**PROJECT
NAME:**

**Kittitas PUD 1 Headquarters SEPA
(SE-26-00003)**

COMMENT OF SEPA THRESHOLD DETERMINATION

Kittitas PUD #1 Headquarters SE-26-00003

CITY OF ELLENSBURG
NATURAL GAS DIVISION
UTILITY MAP REQUEST INFORMATION

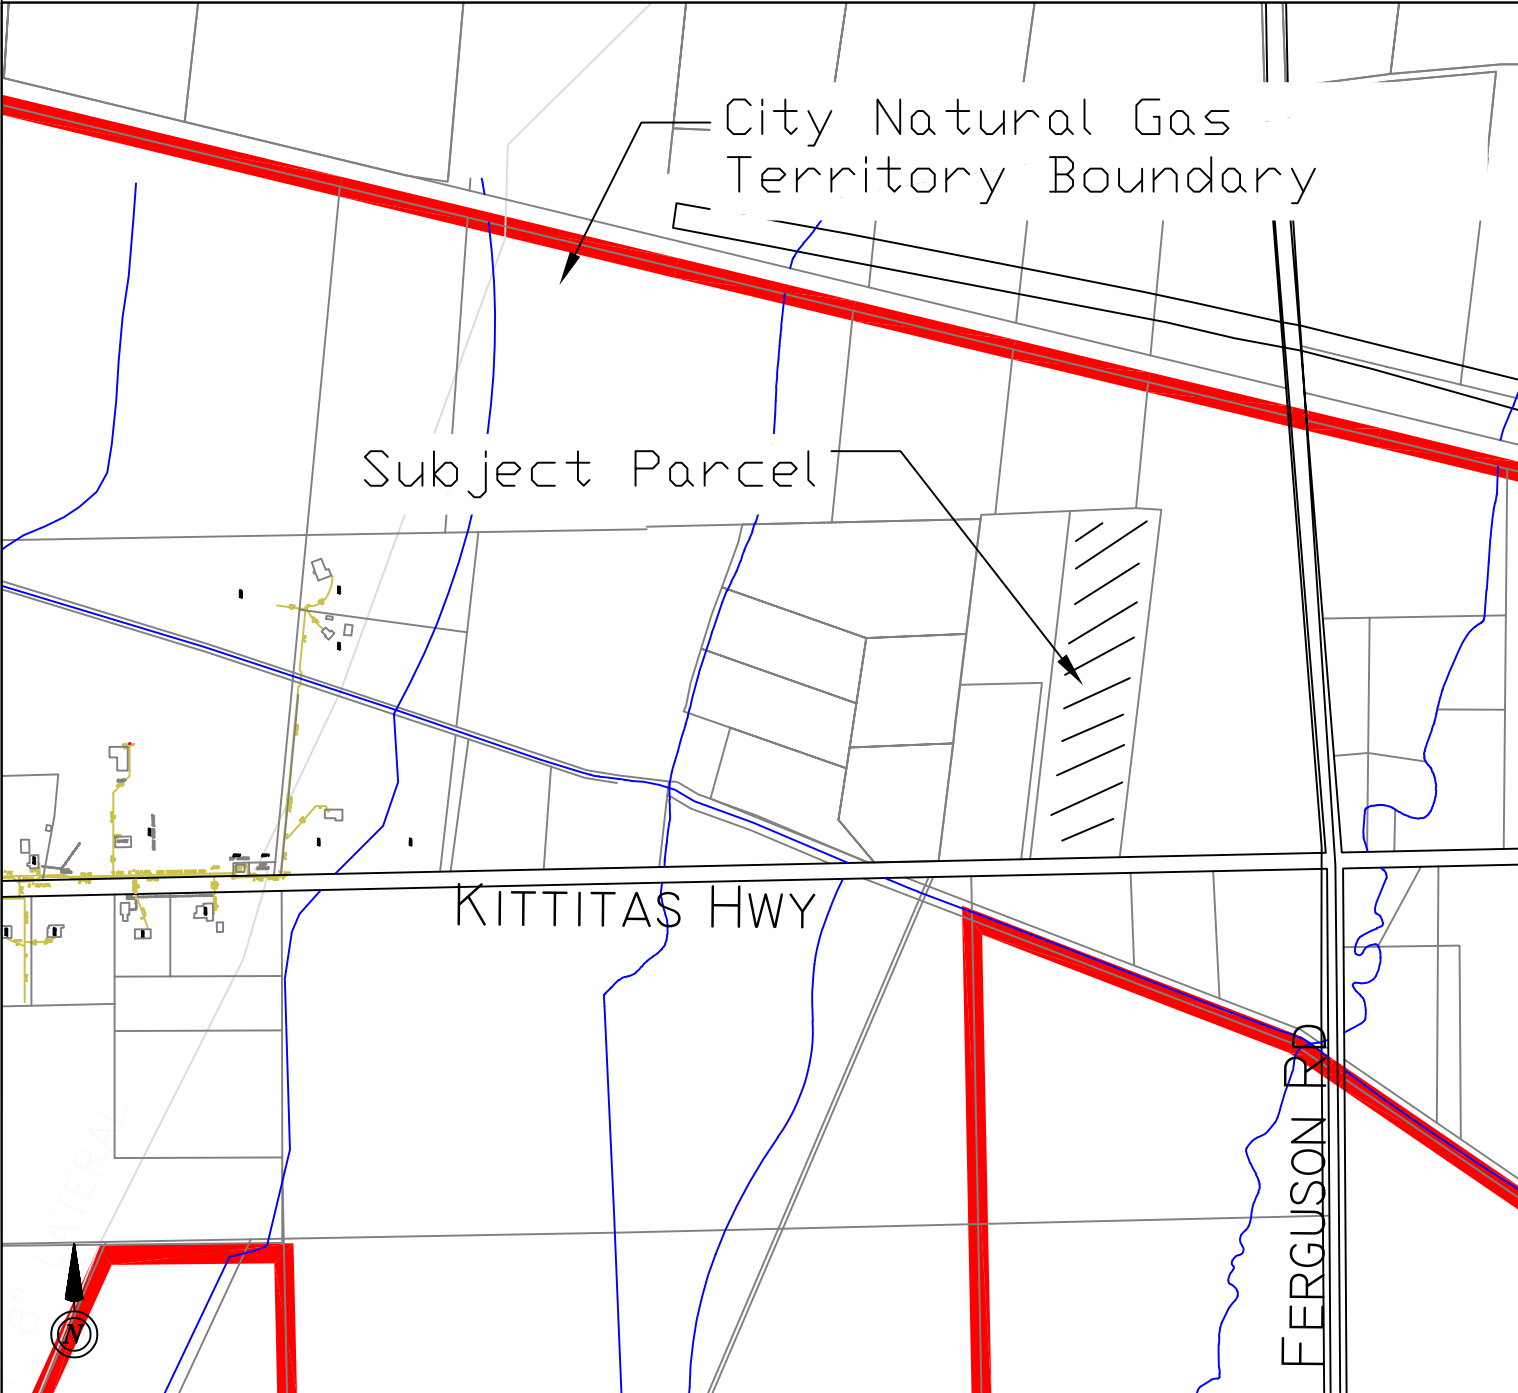
A natural gas utility map is attached showing the existing infrastructure in the vicinity. The subject parcel is within the City of Ellensburg Gas Division Territory.

If natural gas is requested to be utilized for this parcel/development, the gas main will need to be extended to the property. Puget Sound Energy (PSE) also has natural gas in the vicinity, which is utilized to extend into their territory, not to serve customers within the City's territory. There are provisions to allow use of PSE gas within the City territory, but this will need to be discussed with the City Gas Engineer before any approval is granted and must fall within the guidelines of those written provisions.
